WEST SUSSEX COUNTY COUNCIL CONSULTATION

TO:	Arun District Council FAO: Simon Davis
FROM:	WSCC - Highways Authority
DATE:	28 May 2019
LOCATION:	Yapton Metal Company Burndell Road Yapton BN18 0HP
SUBJECT:	Y/42/19/DOC Approval of details reserved by condition imposed under ref Y/53/16/PL relating to Condition Nos 3 - surface water drainage, 4 - maintenance & management of SuDs system, 5 - site set up and 7 - protective fencing/site monitoring.
RECOMMENDATION:	More Information

Site Plan (Proposed) 1:200

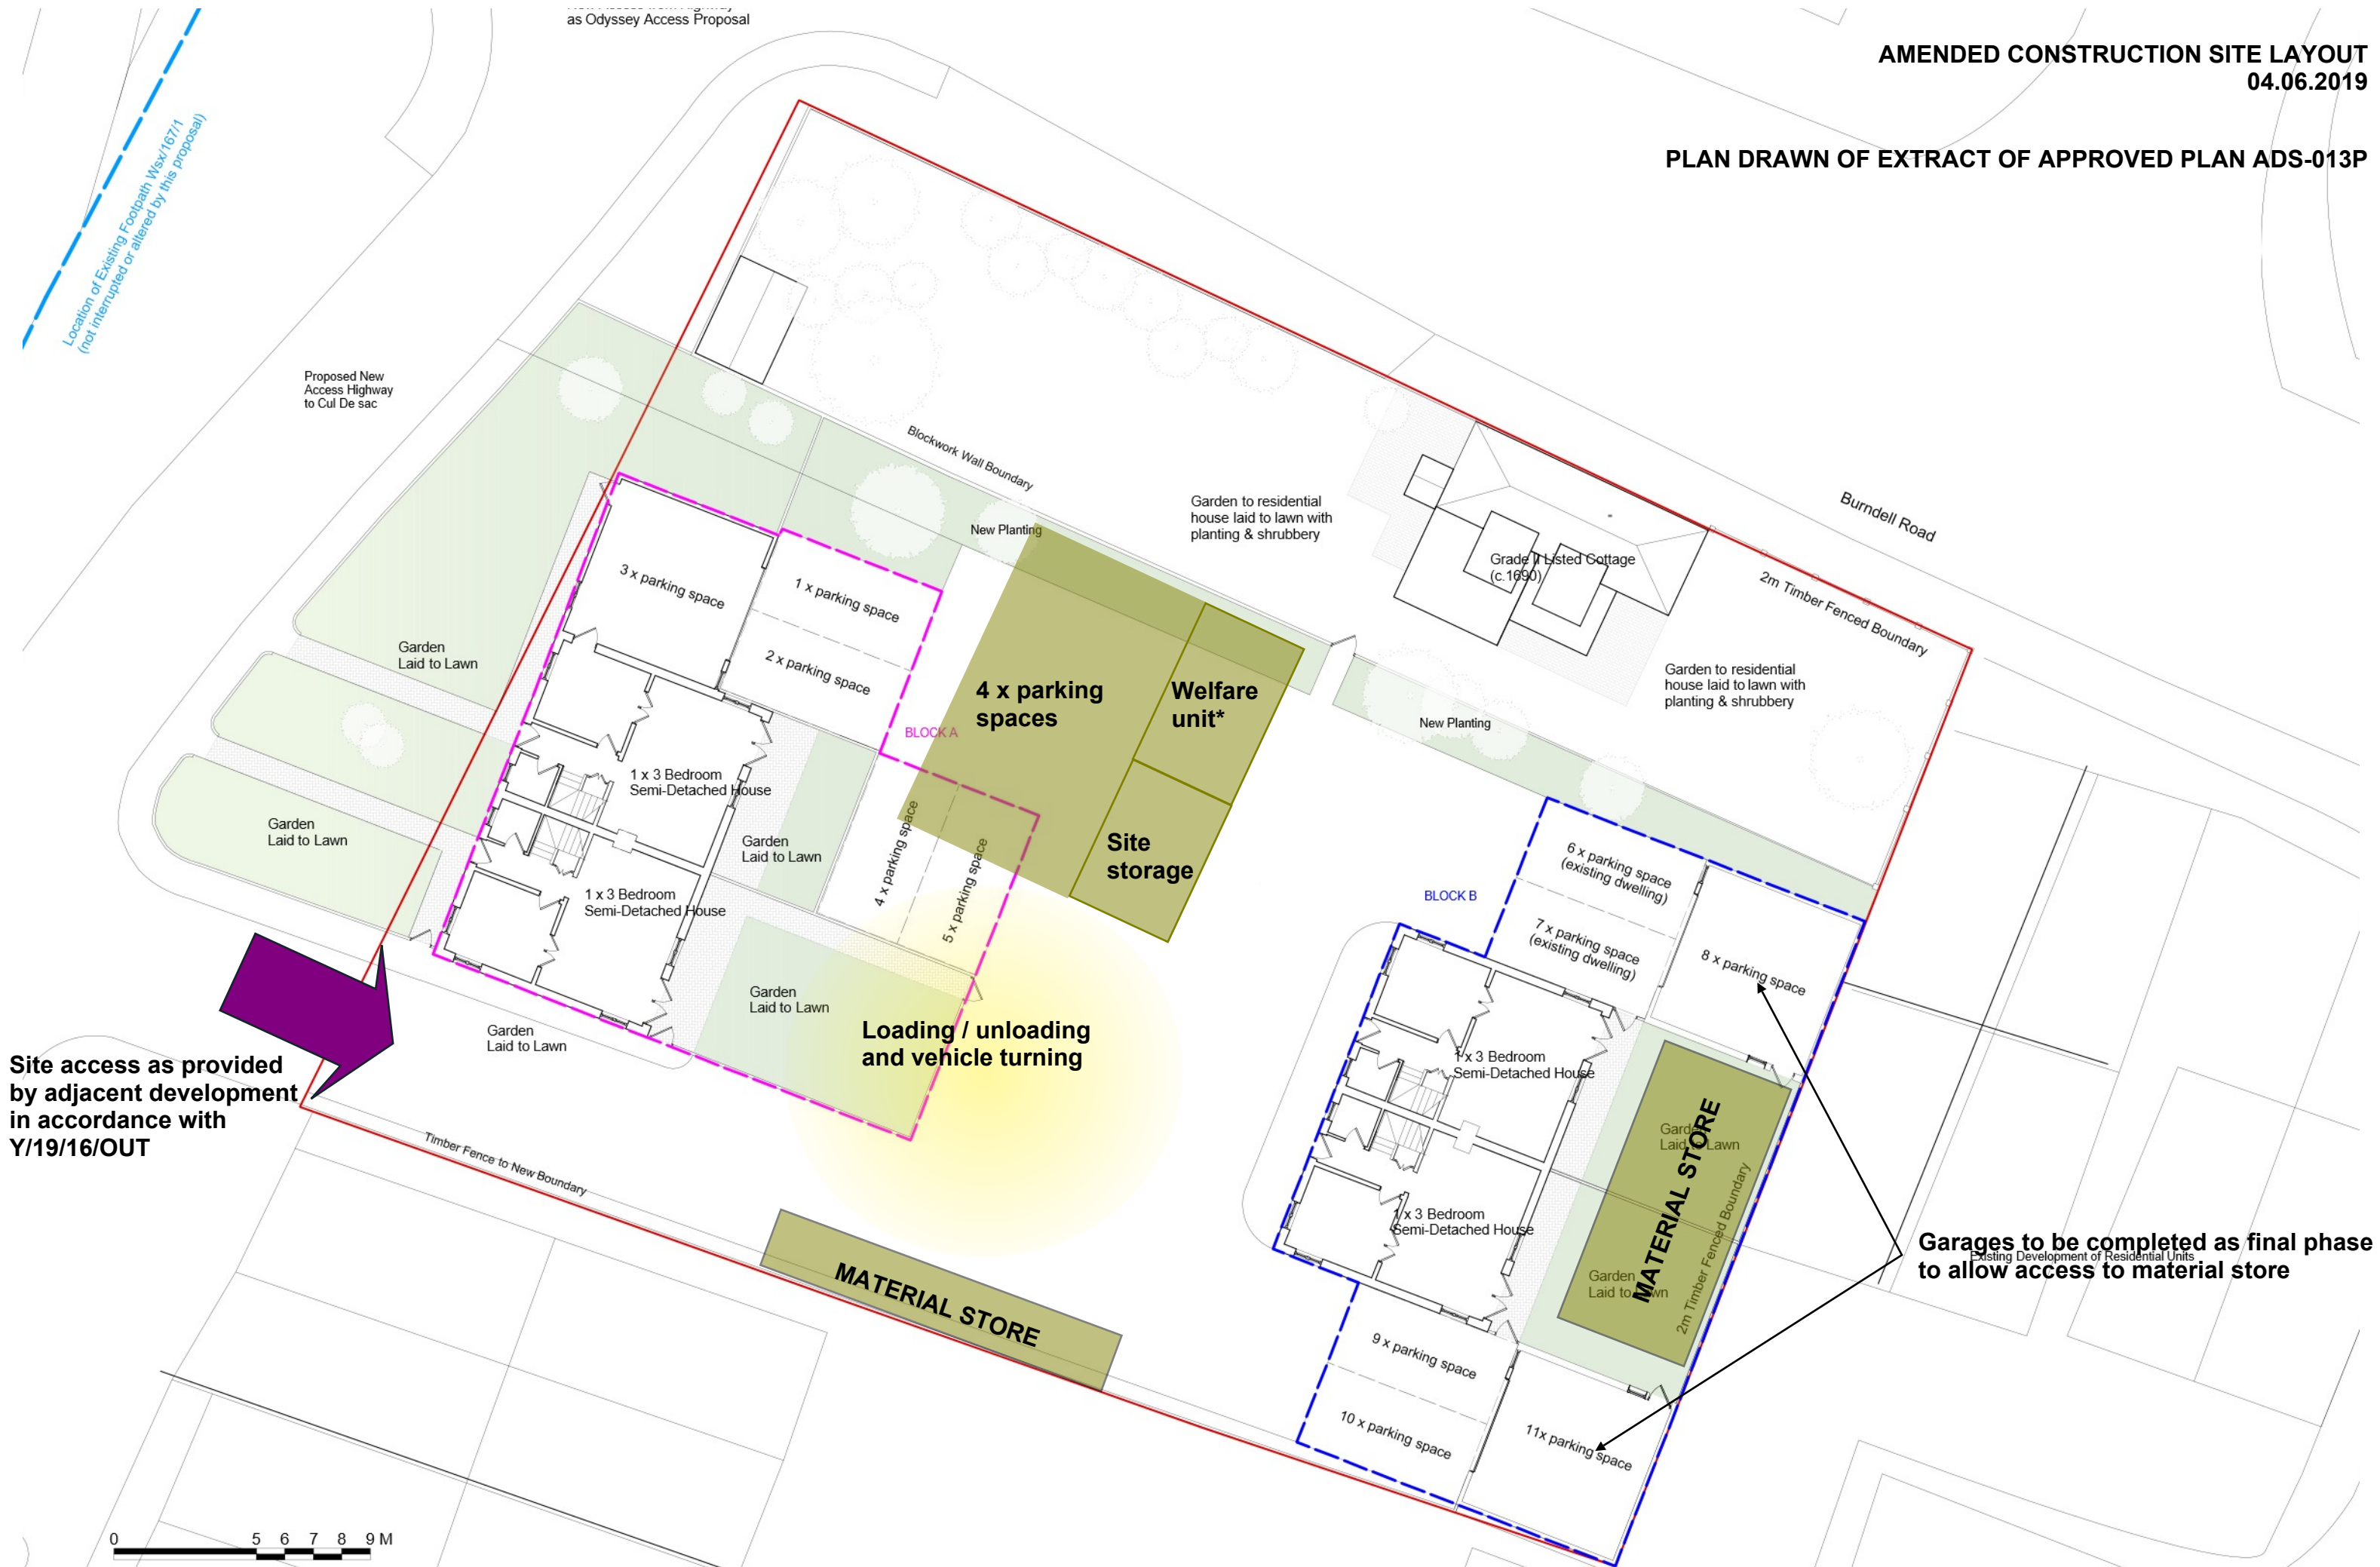
It is not clear whether this plan is to scale, furthermore, clarification is required regard the proposed access arrangements. The plan annotates that shared access with development approved under Y/19/16 will be available after 6th June 2019. Prior to this temporary access to the site from Burndell Road will be provided. From an inspection of local mapping there is no dropped kerb to the access hatched blue and this appears to go through verge and flint wall boundary of existing property Wayside. The applicant should clarify these arrangements and provide additional info on the following:

- will large vehicles be expected to deliver within the site and turn on site - this does not appear achievable with the current site set up.
- provide clearer indication of access arrangements including access width and clear space within the site to allow access to parking area.
- where will the area for loading/unloading be? can the existing access to Burndell Yard be utilised for a through route?
